PLANNING DECISION NOTICE

S6/2005/992/FP

ERECTION OF FRONT BOUNDARY DWARF WALL AND 1.6 METRE HIGH PIERS (RETROSPECTIVE)

at: 23 TOLMERS AVENUE, CUFFLEY, POTTERS BAR,

Tolmers Avenue CUFFLEY

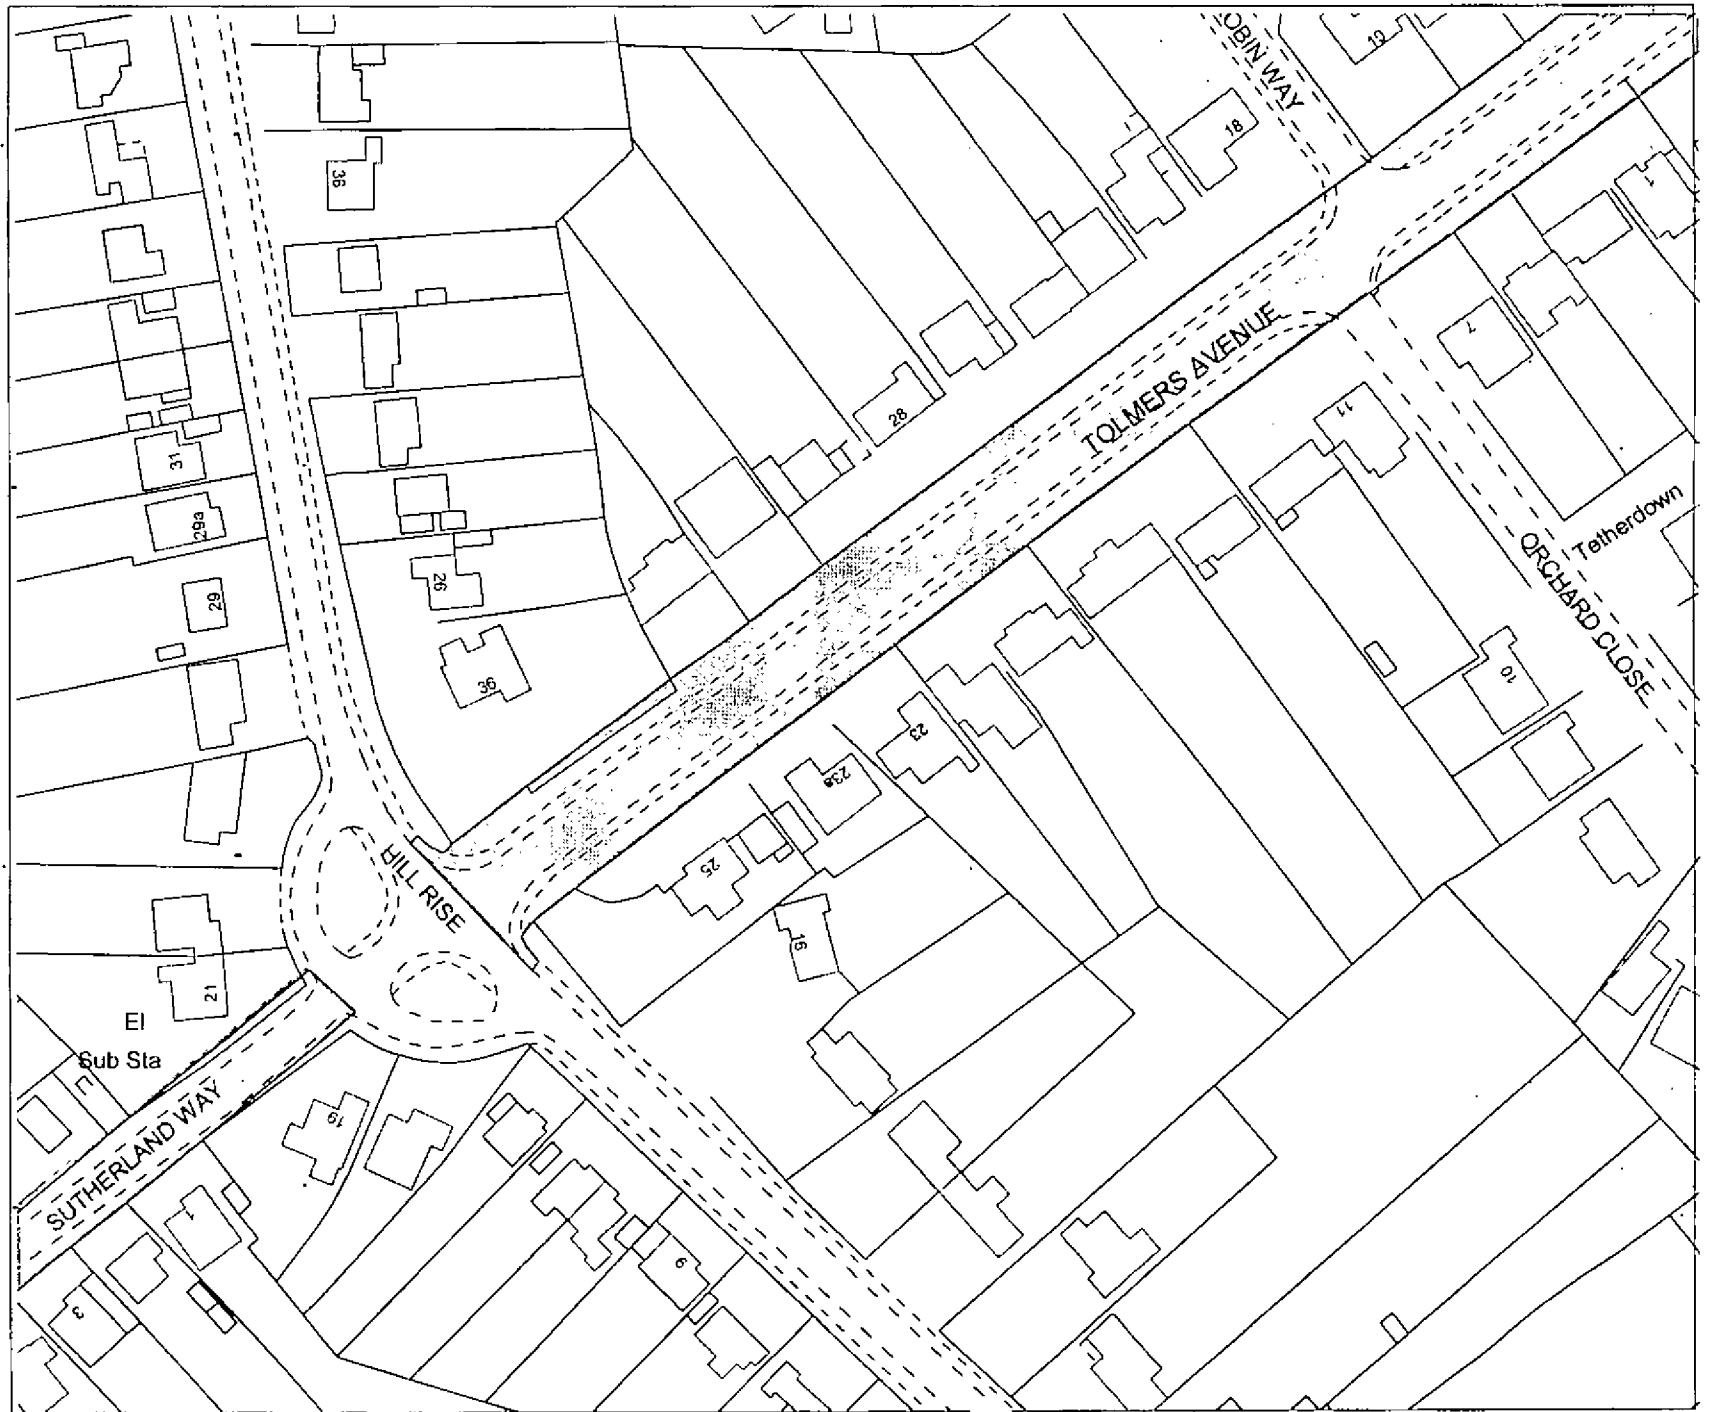
Please note that the existing brick wall structure to the front of your property has been erected outside the curtilage of your property on highway land which is owned by Hertfordshire County Council as the Highway Authority. The front boundary of your property lies approximately 3 metres from the edge of the footpath, as shown on the attached plan, and this should be reflected in your title deeds.

Therefore I would advise that the existing boundary wall should be removed from the highway land.

FRONT BOUNDARY WALL ELEVATION - 1:50

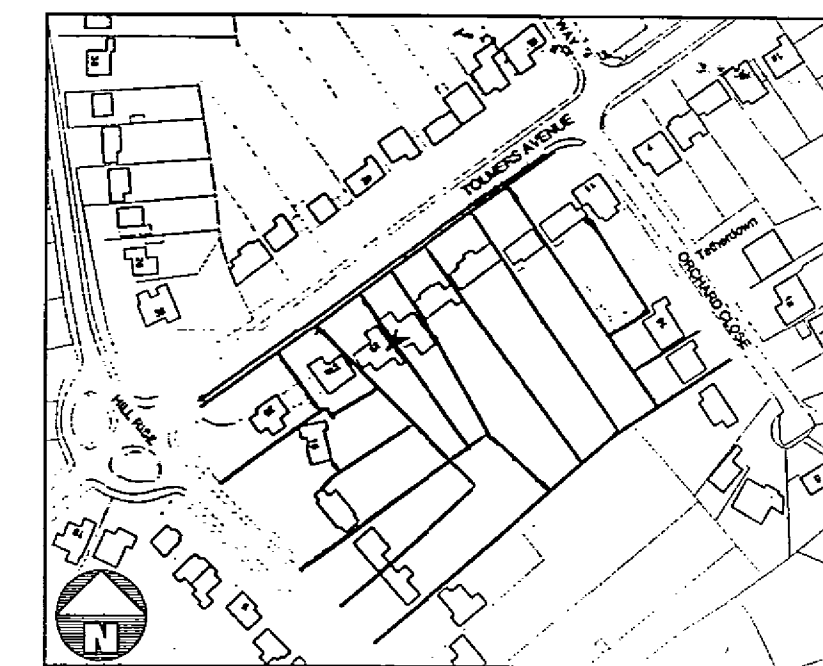
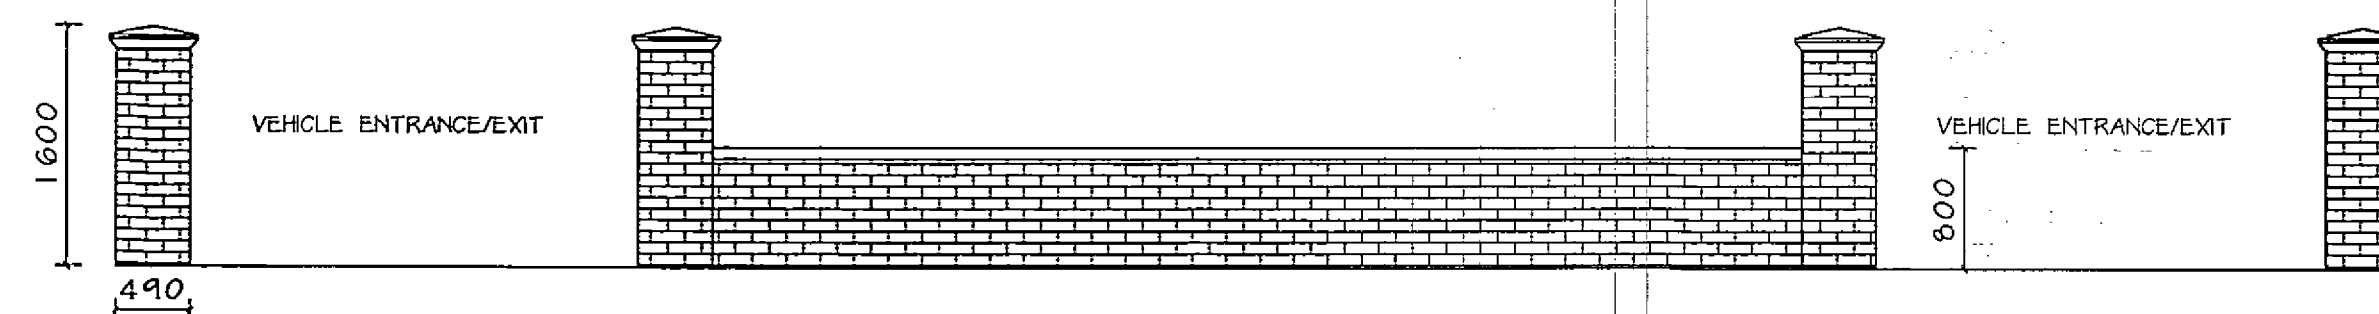
The wall and brick piers, by reason of their design, materials, size and siting, give rise to an unduly prominent form of development, out of keeping with the generally open character of property frontages in this part of Tolmers Avenue. As such the wall and brick piers are detrimental to the visual amenities of this part of Tolmers Avenue and contrary to Policies D1 and D2 of the Welwyn Hatfield District Plan 2005.
